Application no: H13-0161-12

Description: Proposed extension and detached garage

Location: 16 Roman Road
Moulton Chapel
Spalding
PE12 0XQ

Amendment: Amendments showing french doors on floor plan
(dwg. no. WEN/1468/12/01A)

DRAWING NO: WEN/1468/12/01A	DATE: FEBRUARY 2012
--------------------------------	------------------------

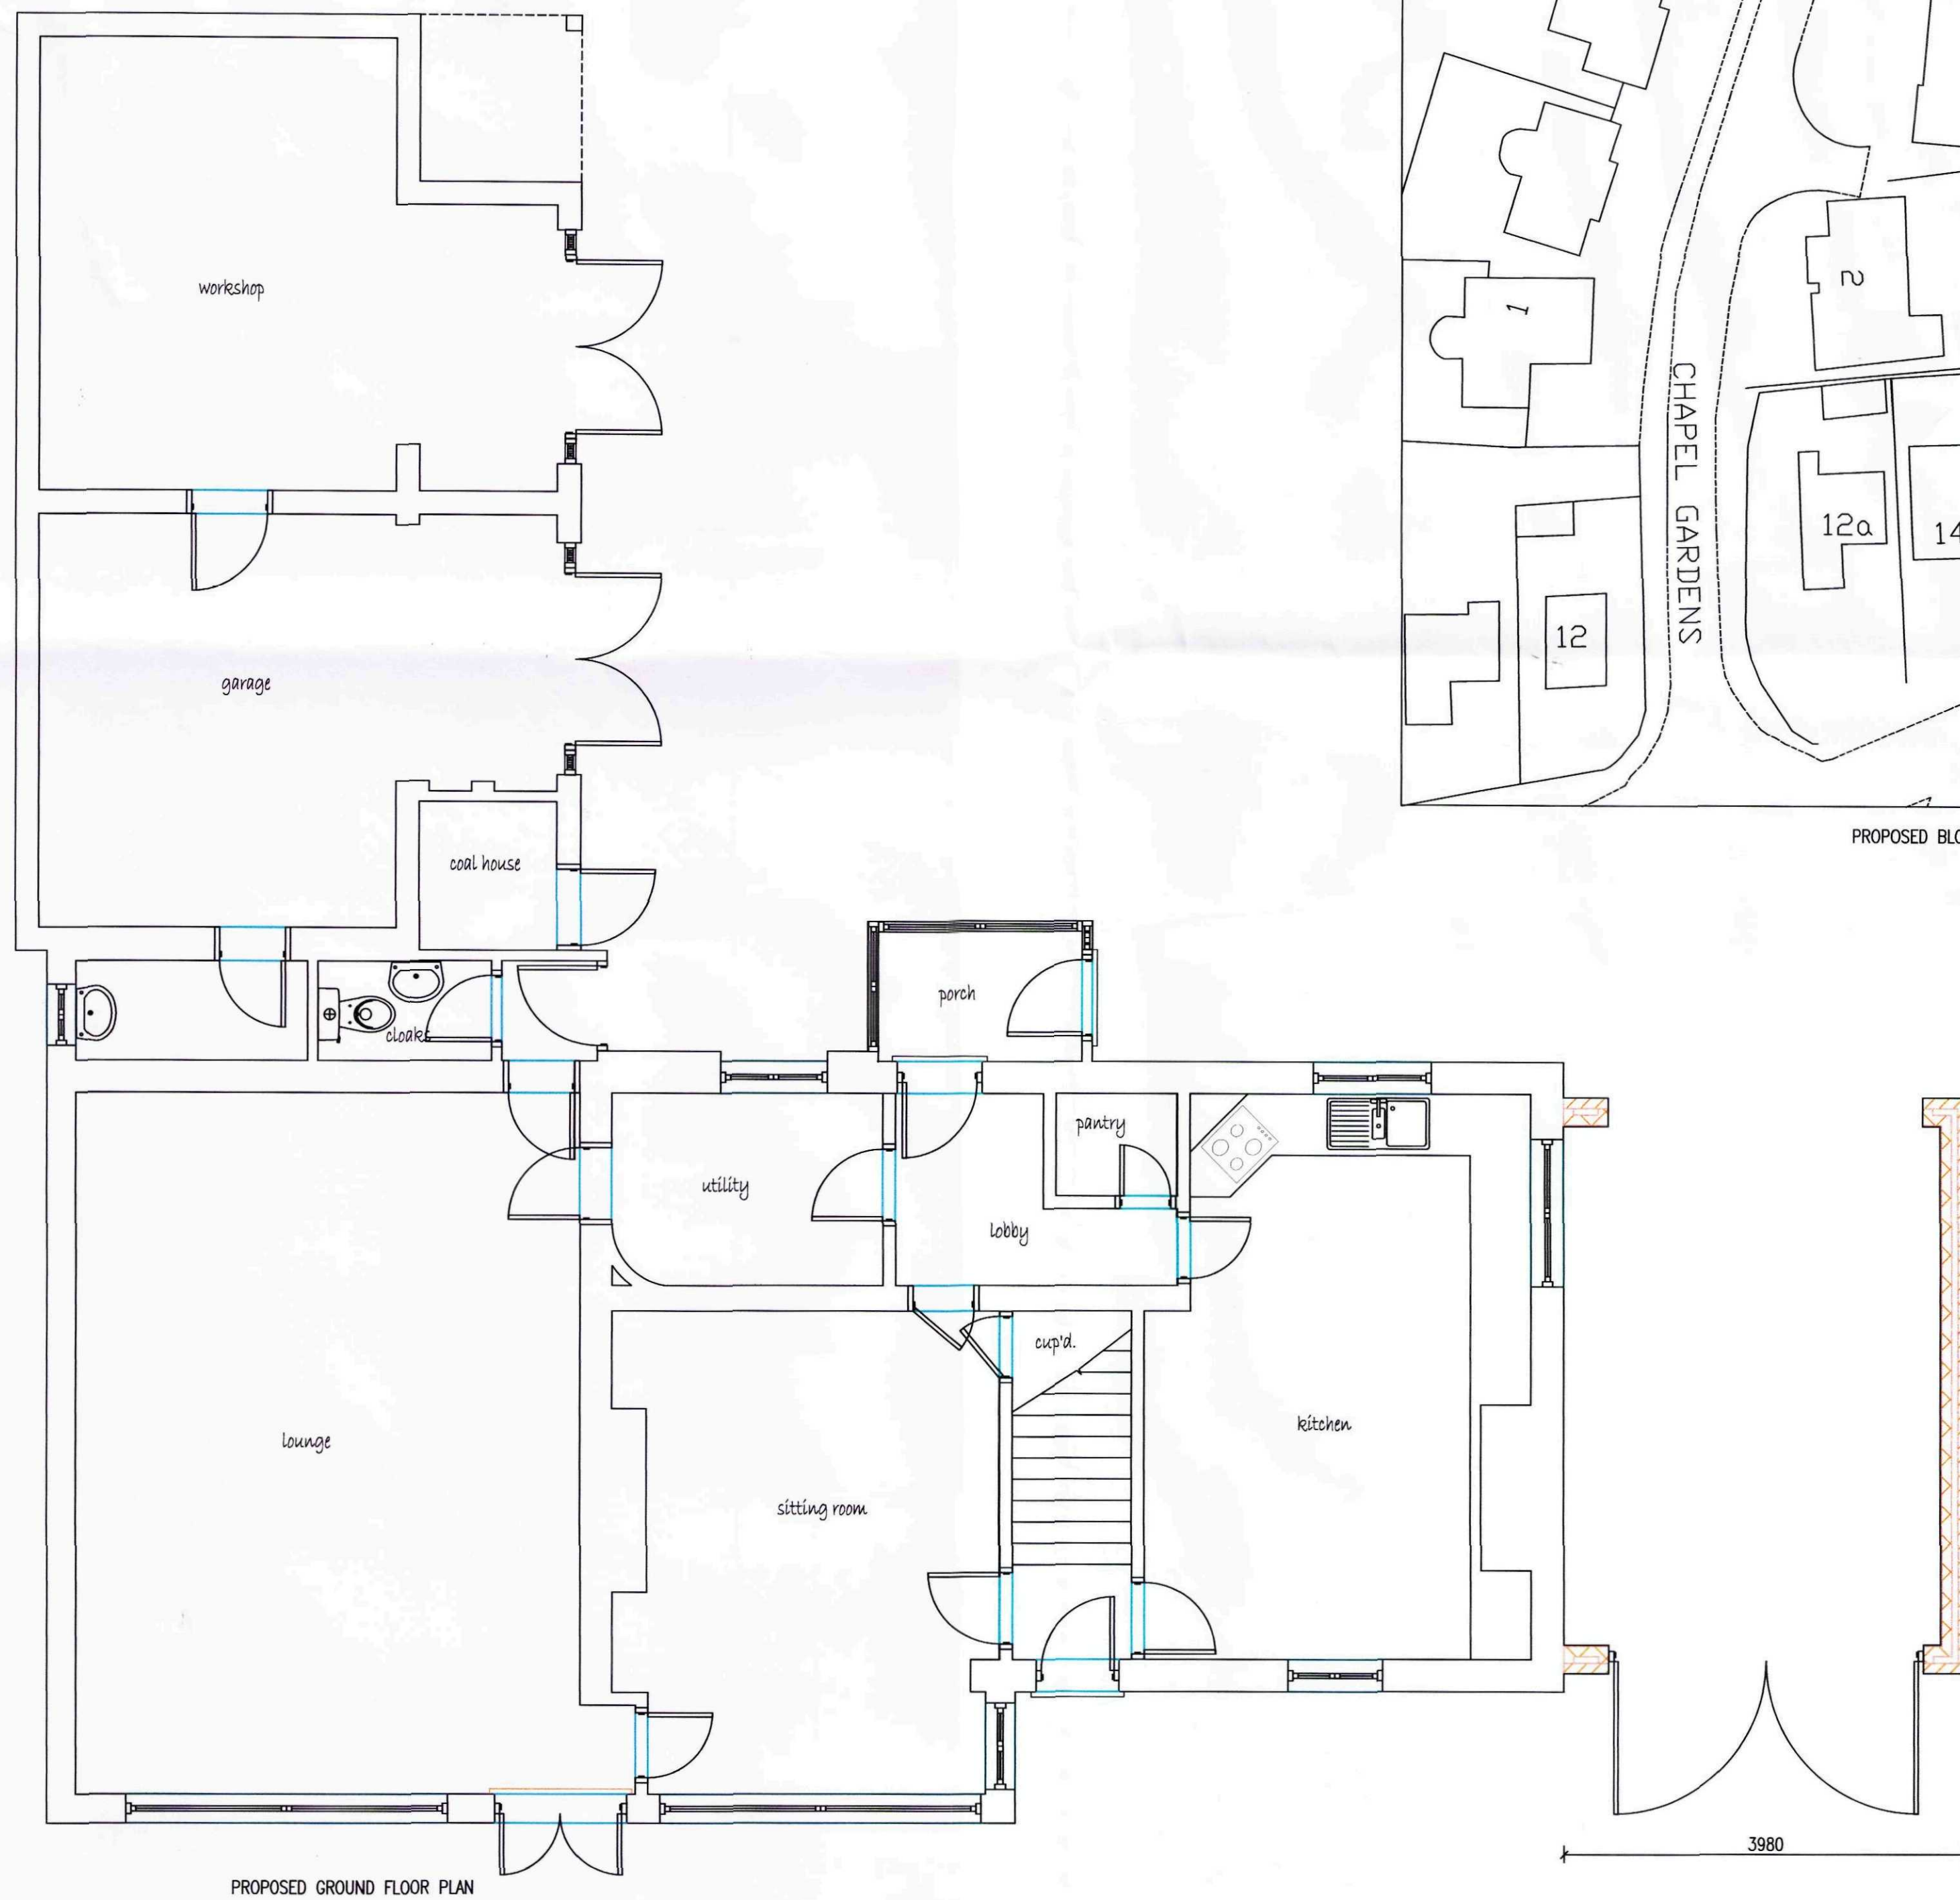
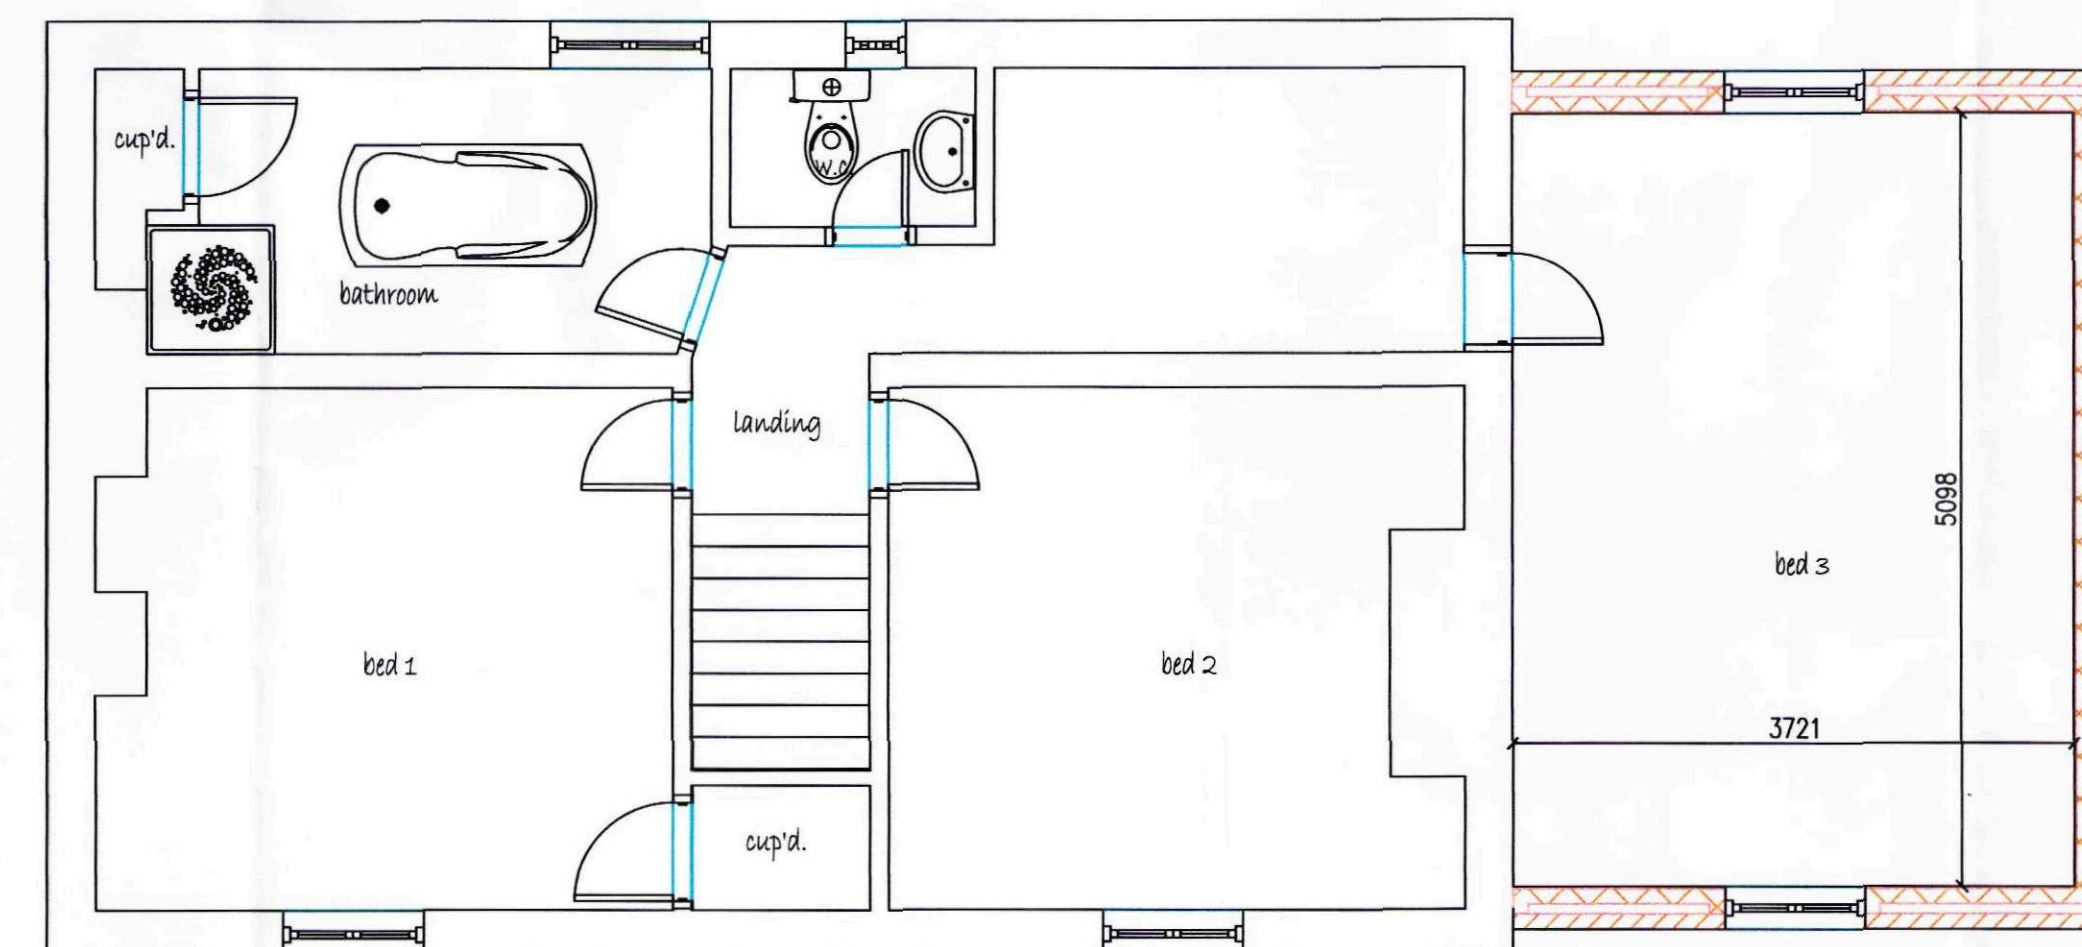
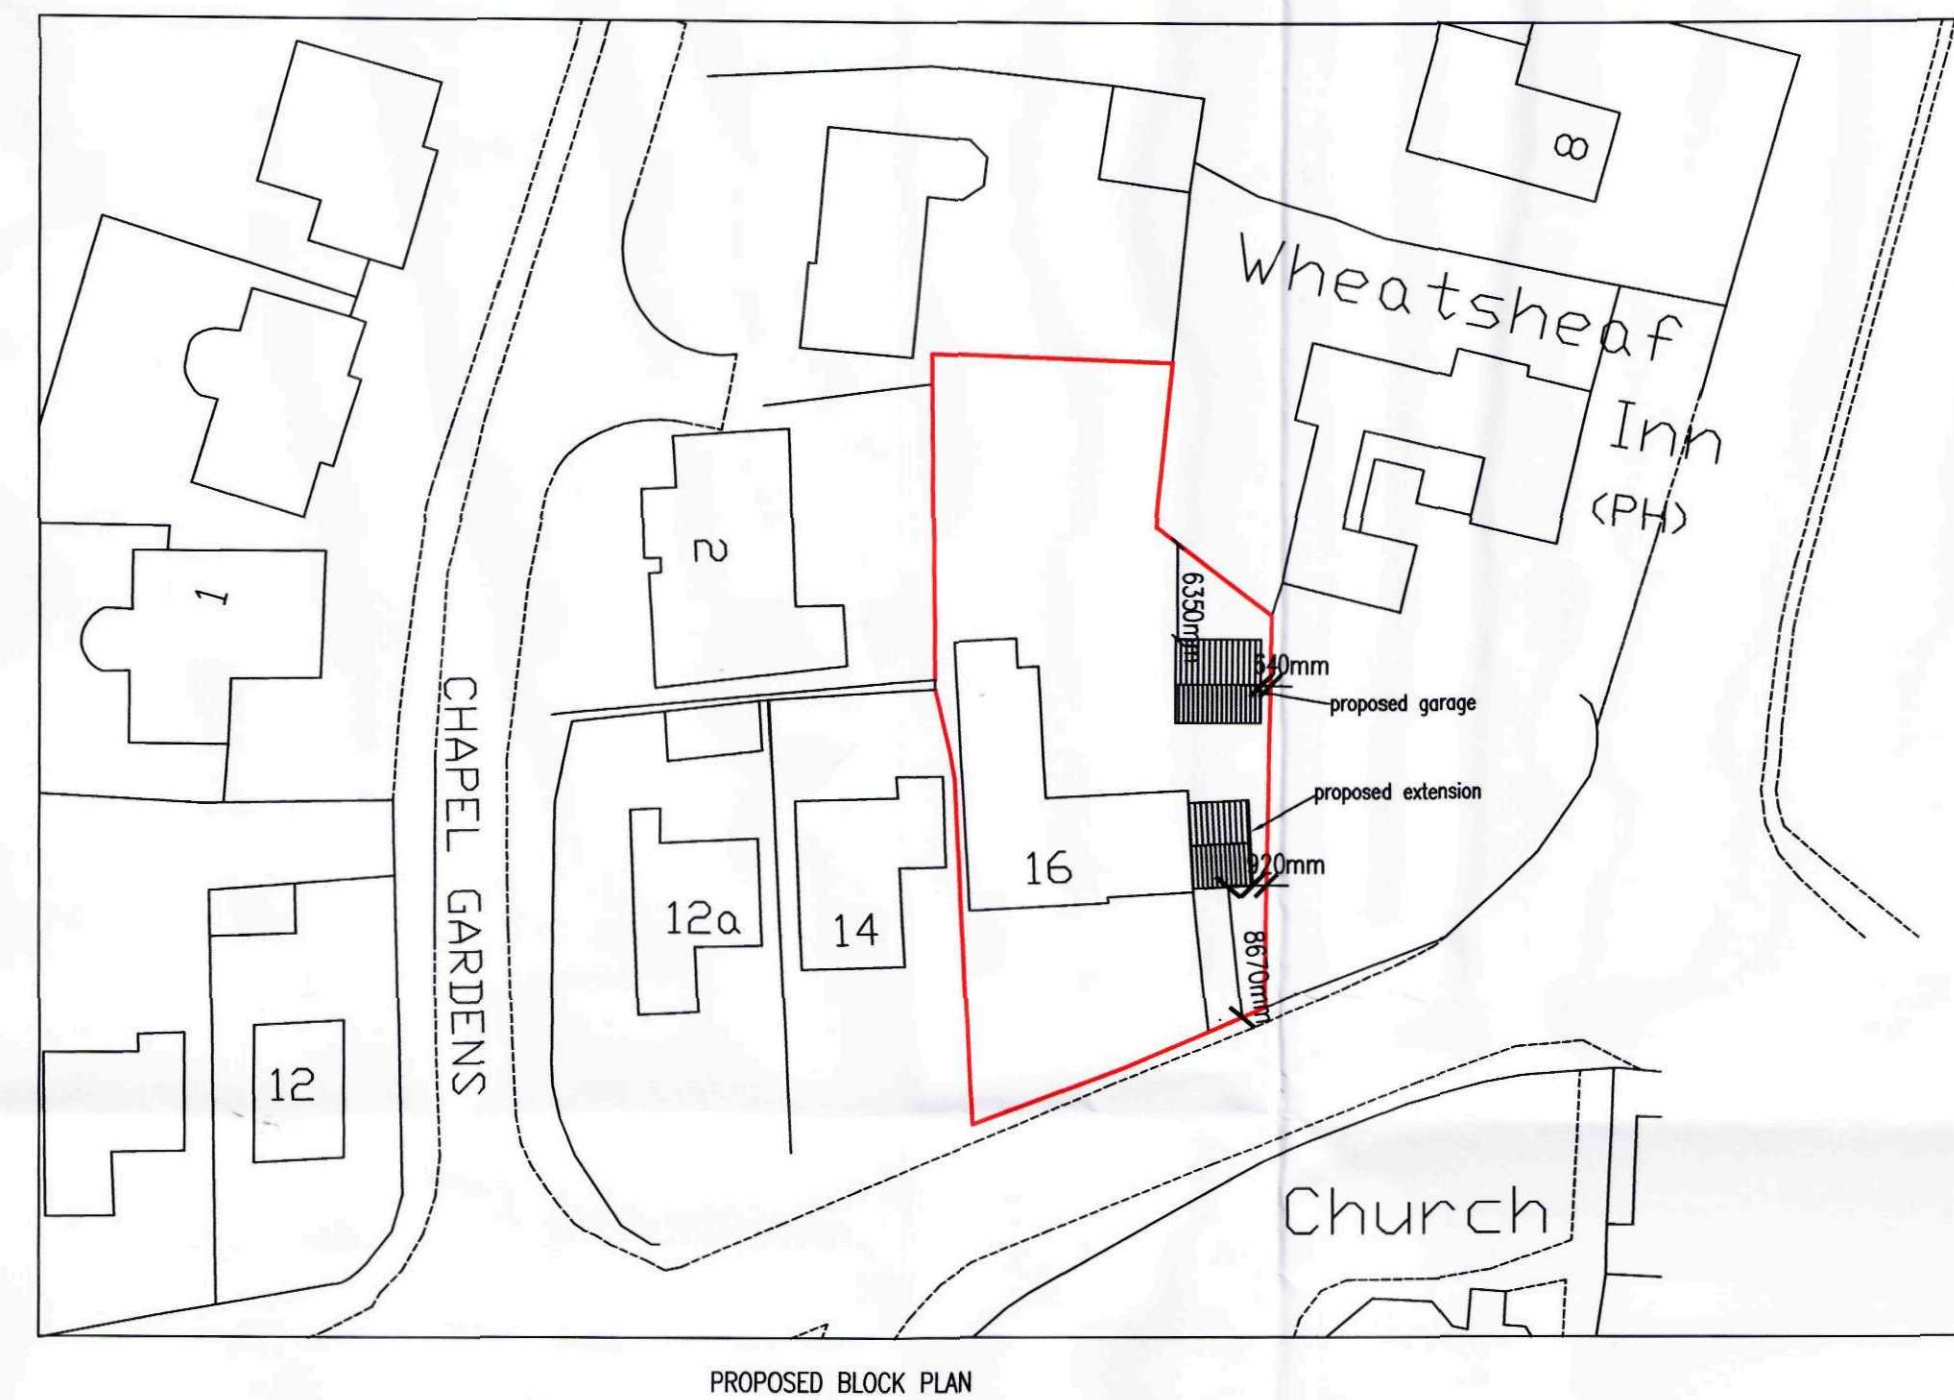
Thank you for your telephone call this morning, please find attached an amended plan showing the French doors on the floor plan.
